## Engineers Comments Regarding Surface Water Drainage

| <b>Application Reference:</b>   | LU/185/25/DOC                                                                                                                                                                                                                                                                                                                                                                                                                                                         | <b>Reviewer Reference:</b> | ADC/EXT2/D2134/83 |
| <b>Site Name:</b>               | Land West of Holly Drive Littlehampton                                                                                                                                                                                                                                                                                                                                                                                                                                |                            |                   |
| <b>Application Description:</b> | Approval of details reserv

Depth from cover level to soffit of pipe 1.5 m to 3.0 m, man-entry

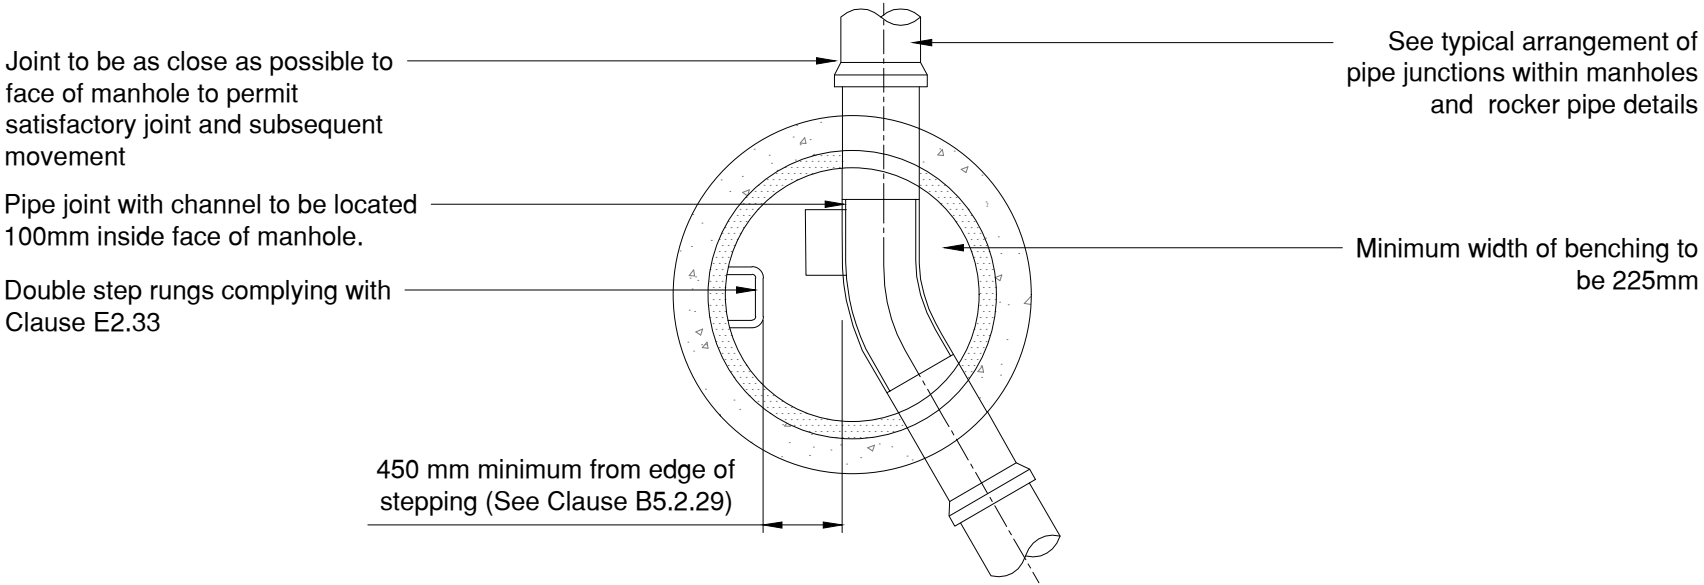
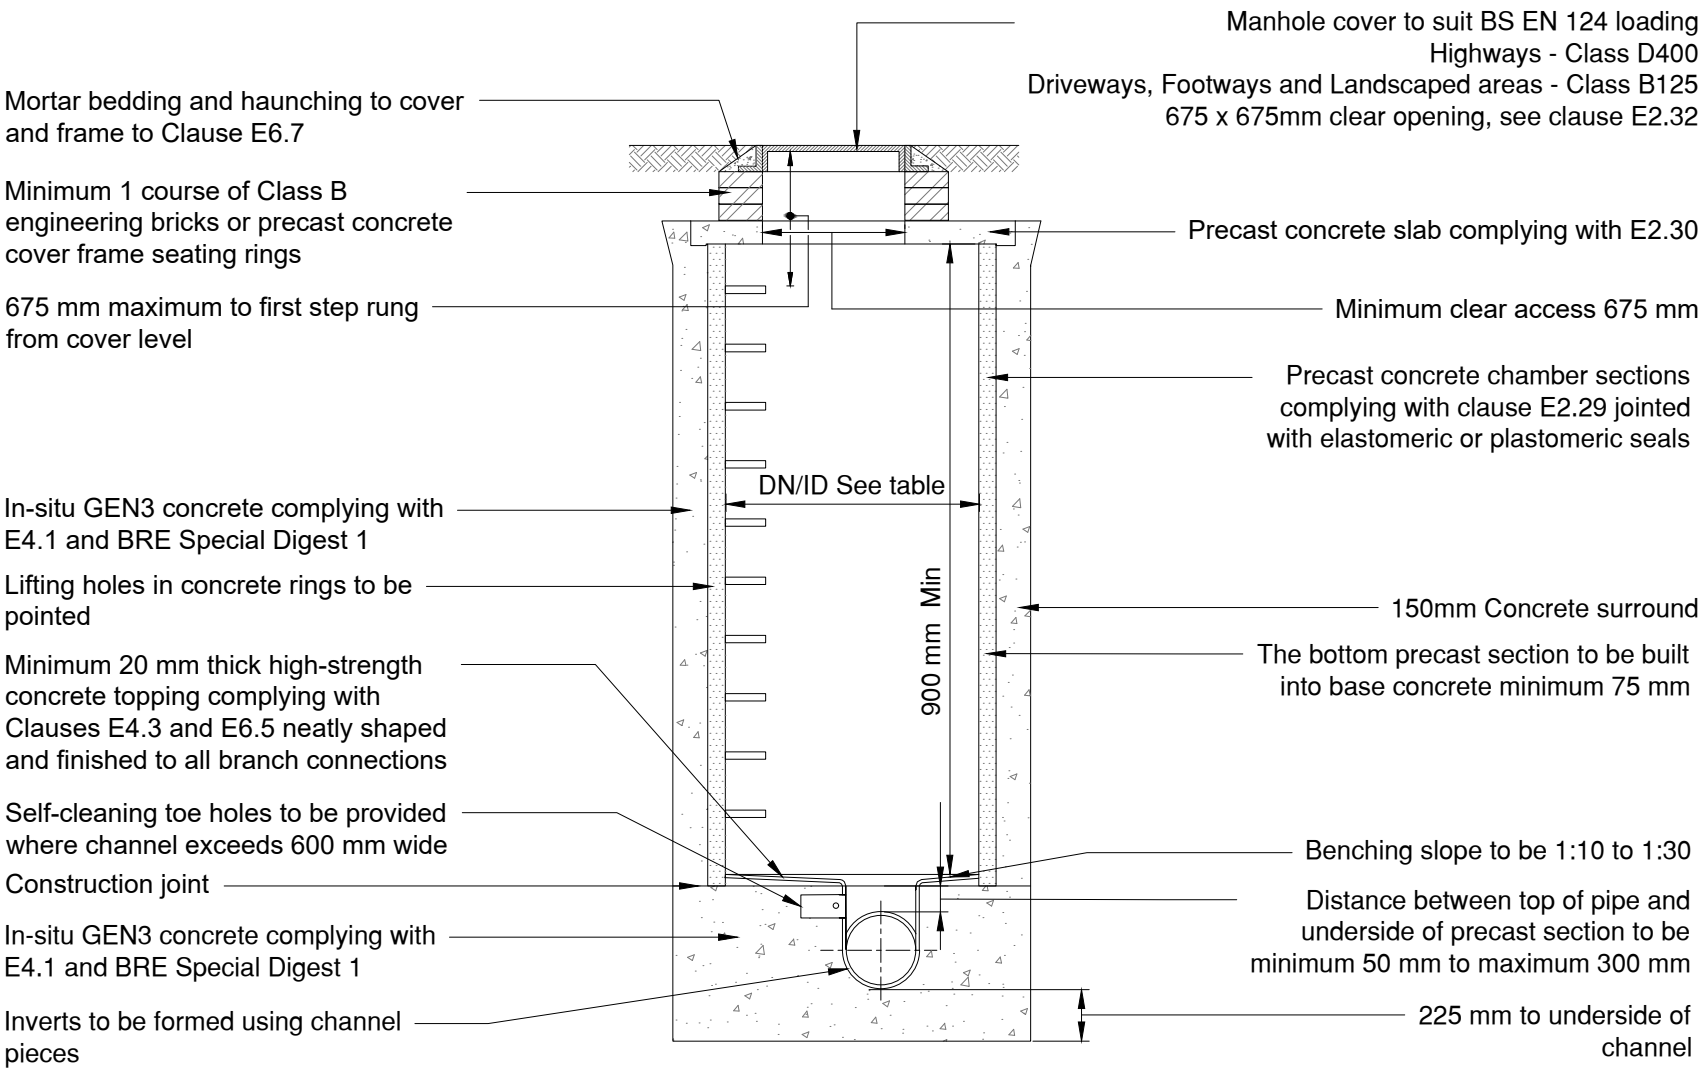
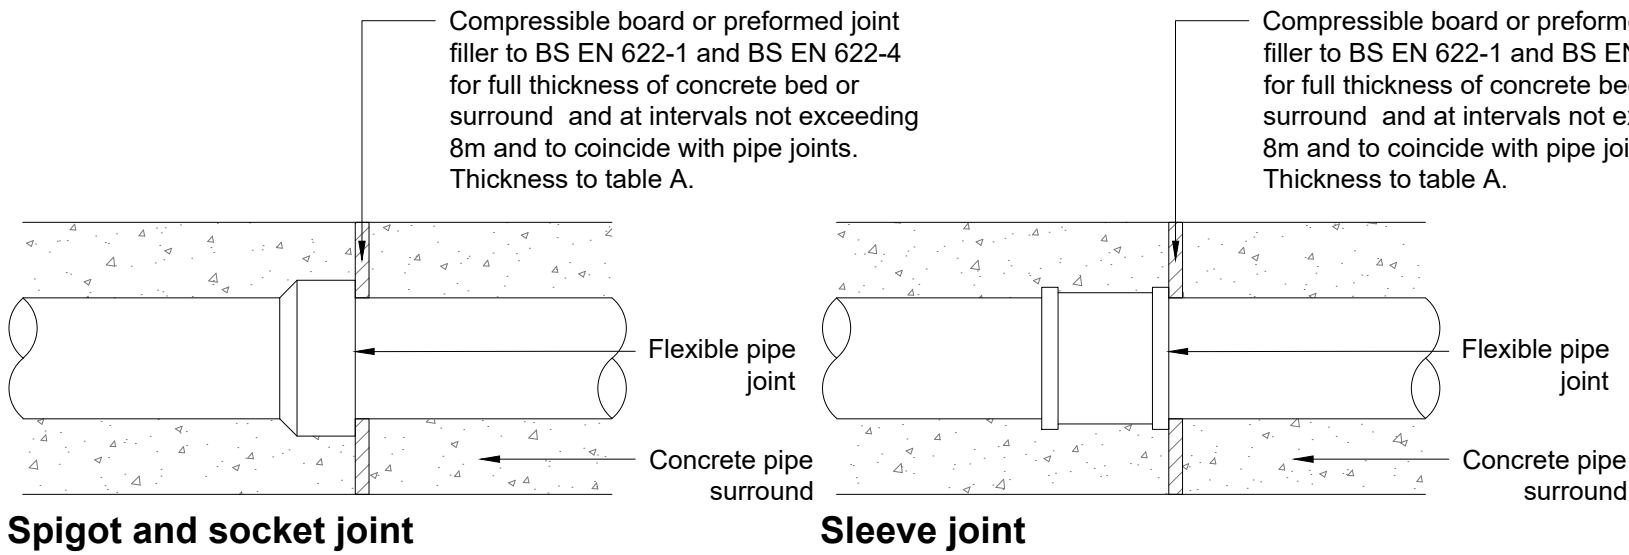
| 13 | Construction details sheet 1 shows a type B manhole which is not used, please remove any details not relevant to the scheme.                                                                              | Catchpit Manhole <b>S1</b> has been specified as a <b>Type B</b> manhole with a <b>500mm</b> deep sump.                                                                                                                                                                   | Comment closed. |  |  |
| 14 | Please include a standard detail for the PCC ring catchpit and qualify the base sump depth.                                                                                                               | Please refer to drawing: <b>519.1.VCE.0505</b> for details of the <b>Type B</b> manhole with a <b>500mm</b> deep sump.                                                                                                                                                    | Comment closed. |  |  |

SCALE AT A1: NTS	DATE: 27.06.2025	DRAWN: SRV	CHECKED: VPI	APPROVED: VPI
PROJECT NO: 519	DRAWING NO: 519.1.VCE.0506	REVISION: T3

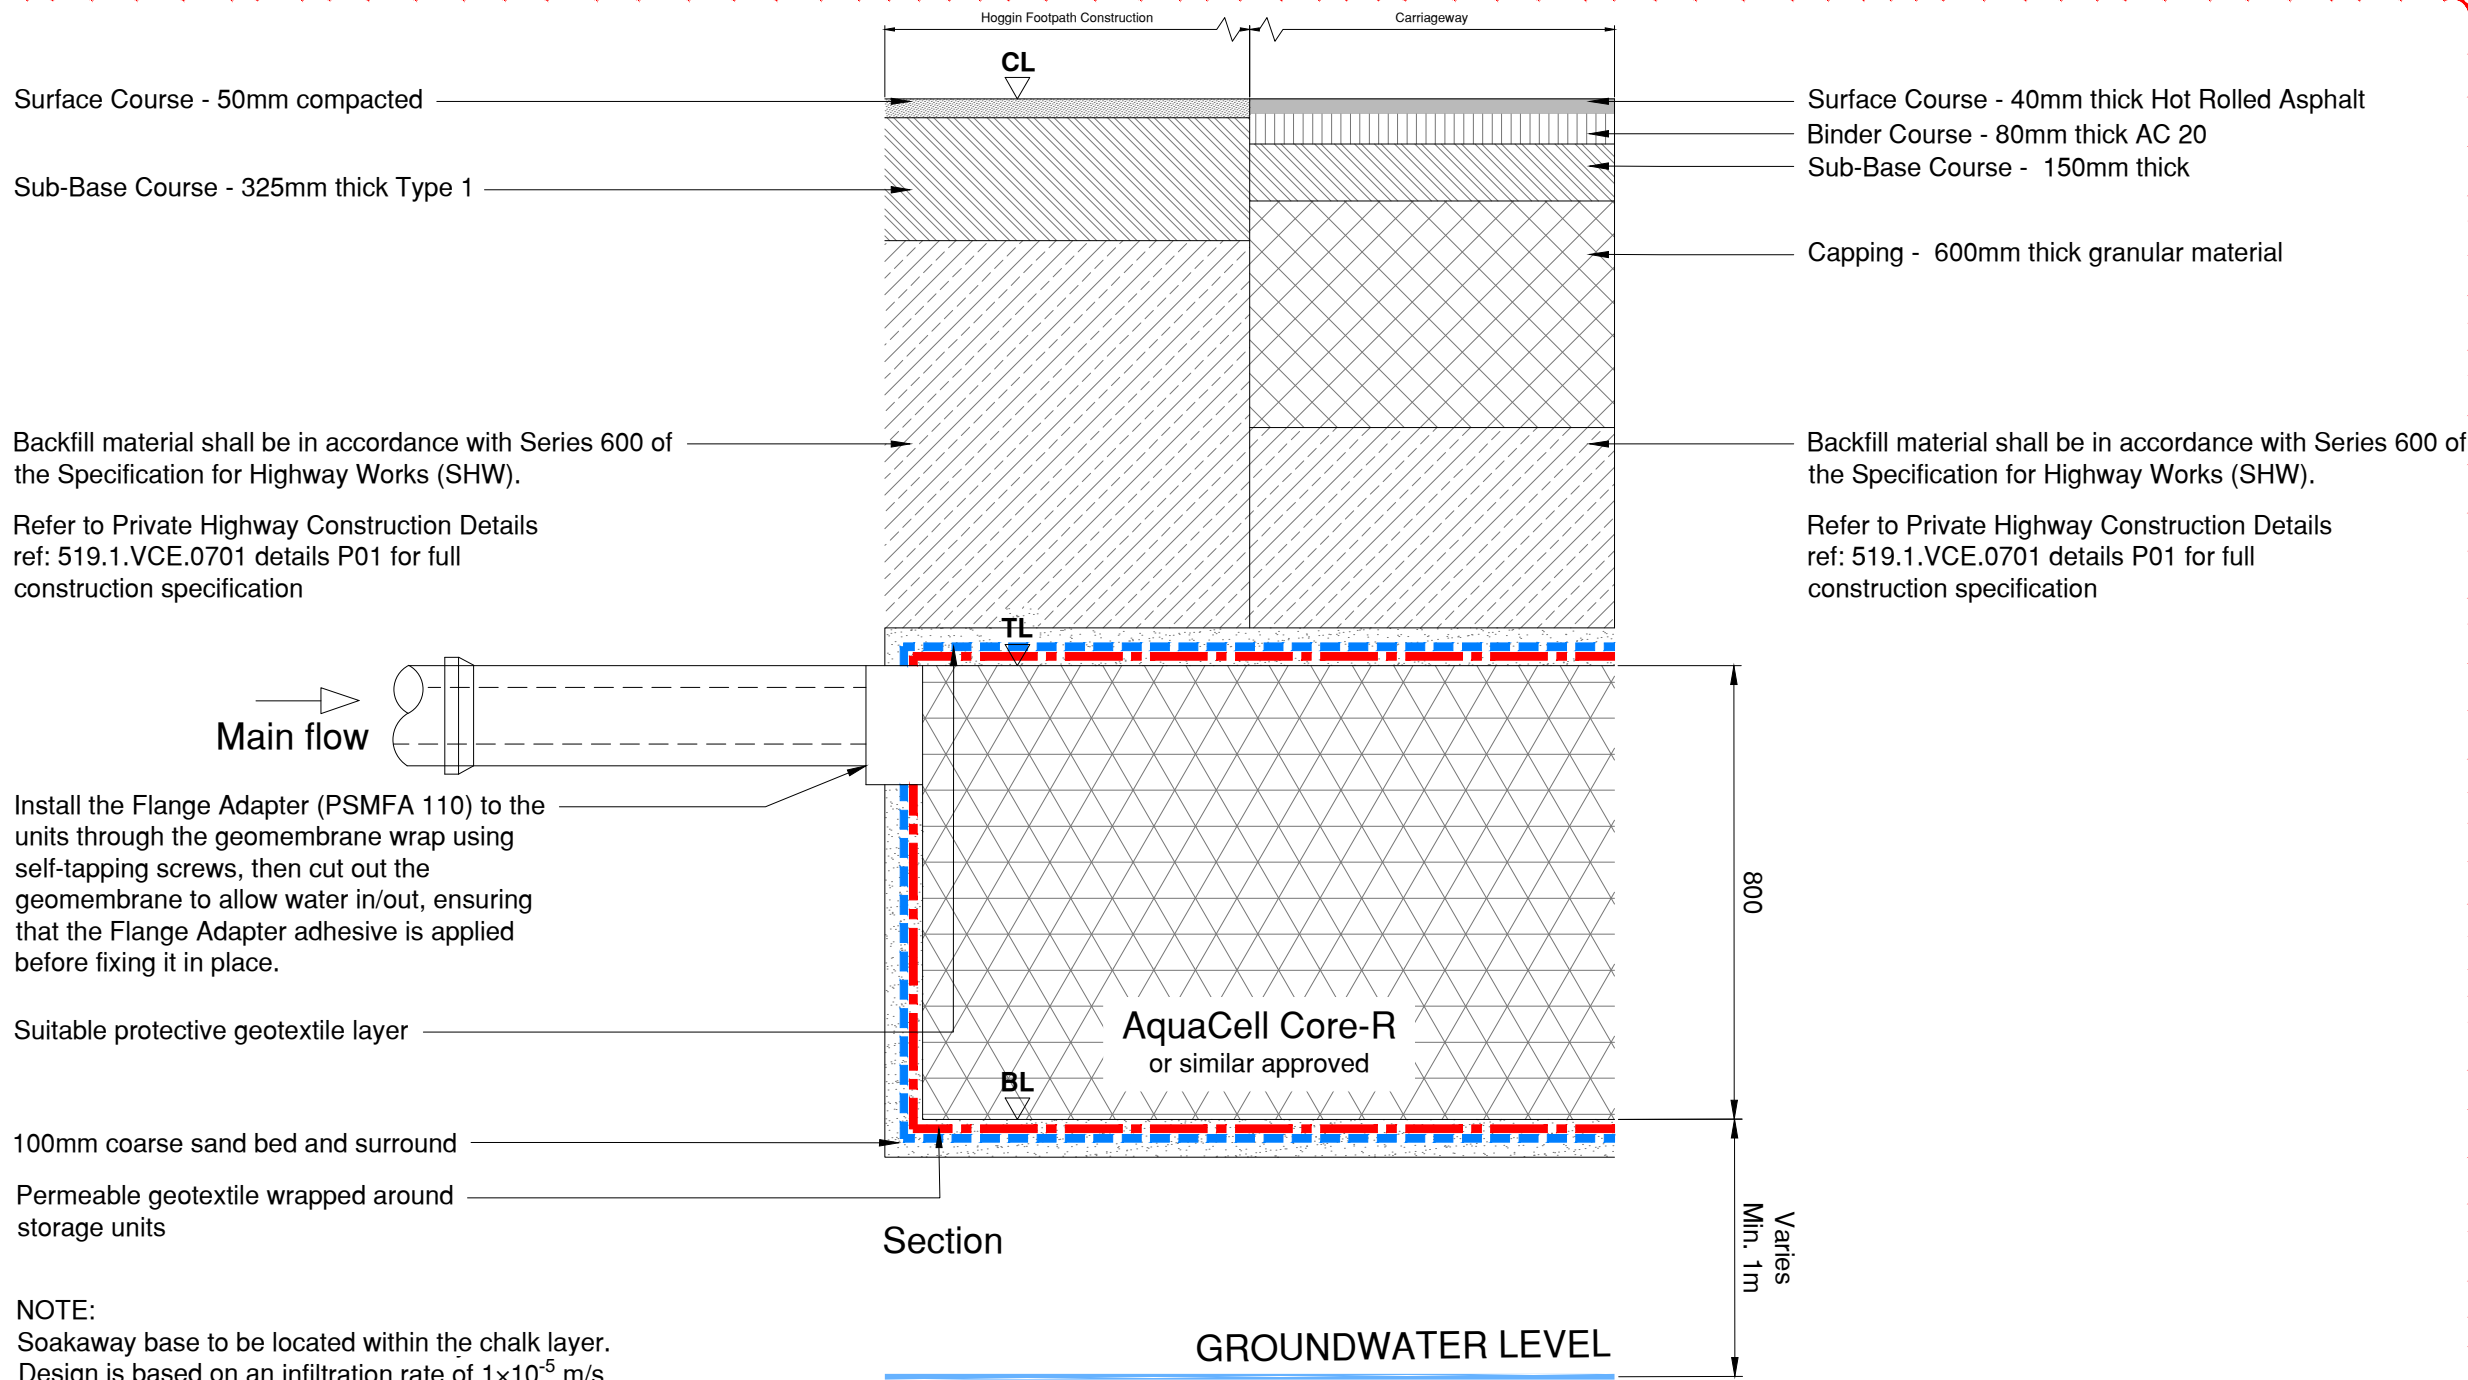
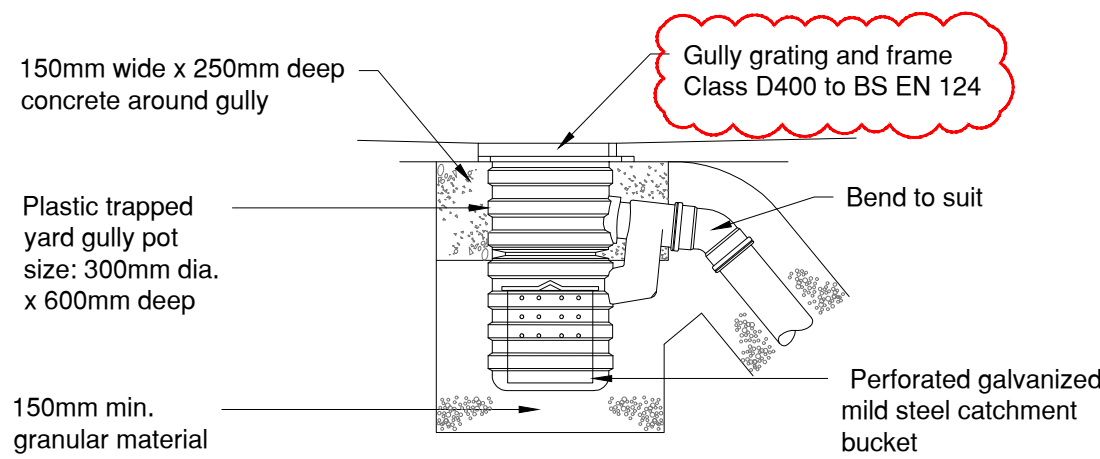
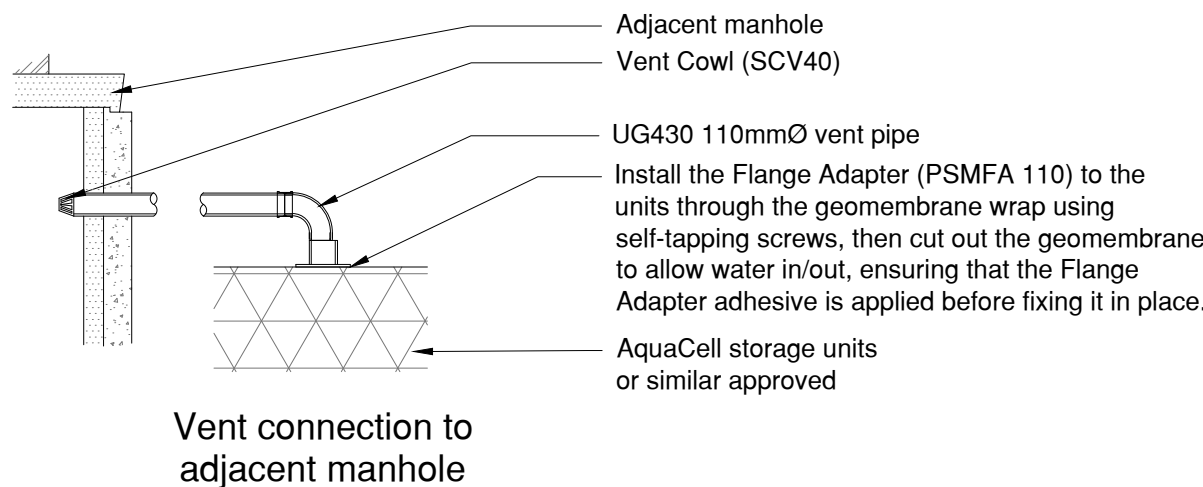
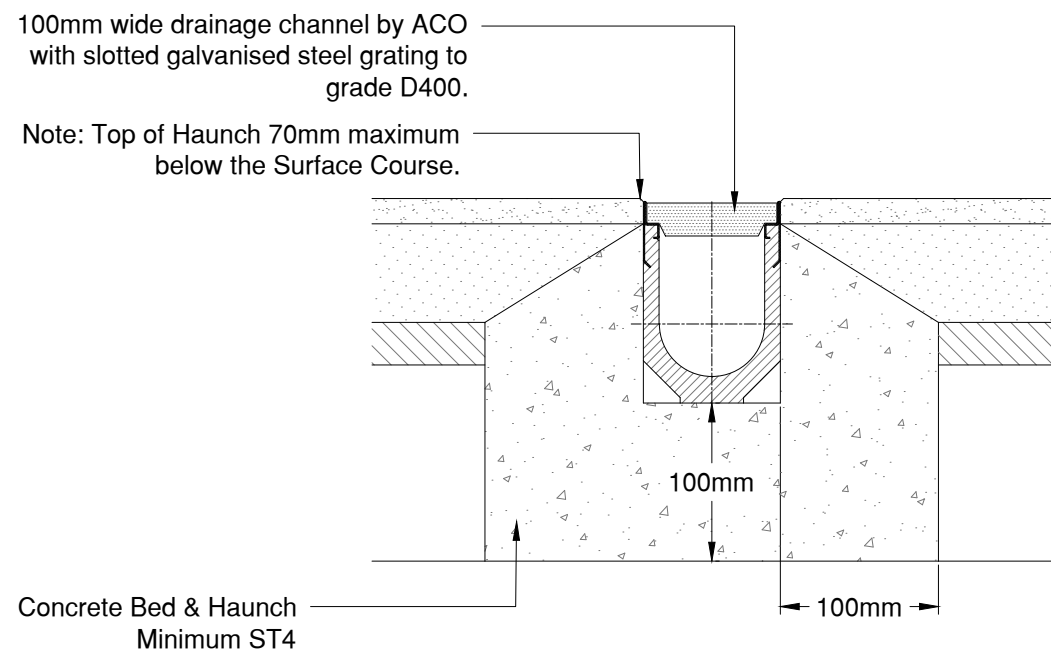
| 12 | Cellular storage criteria does not match drainage plan and details sheet 2 size. This must also correlate with the supplier product being specified.                                                      | The cellular storage detail shown on drawing <b>519.1.VCE.0506</b> and the domestic drainage layout on drawing <b>519.1.VCE.0501</b> are consistent with the accompanying drainage calculations. The specified size accords with the manufacturer's data sheets provided. | Comment closed. |  |  |

| 19 | Construction details sheet 1 shows yard gullies with B125 grade covers which may not be suitable at this location.                                                                 | Please refer to drawing <b>519.1.VCE.0506 T3</b> , where the gully cover grade has been updated to <b>D400</b> to match the specification on the domestic drainage layouts.                                                                                                                                                       | Comment closed. |  |  |
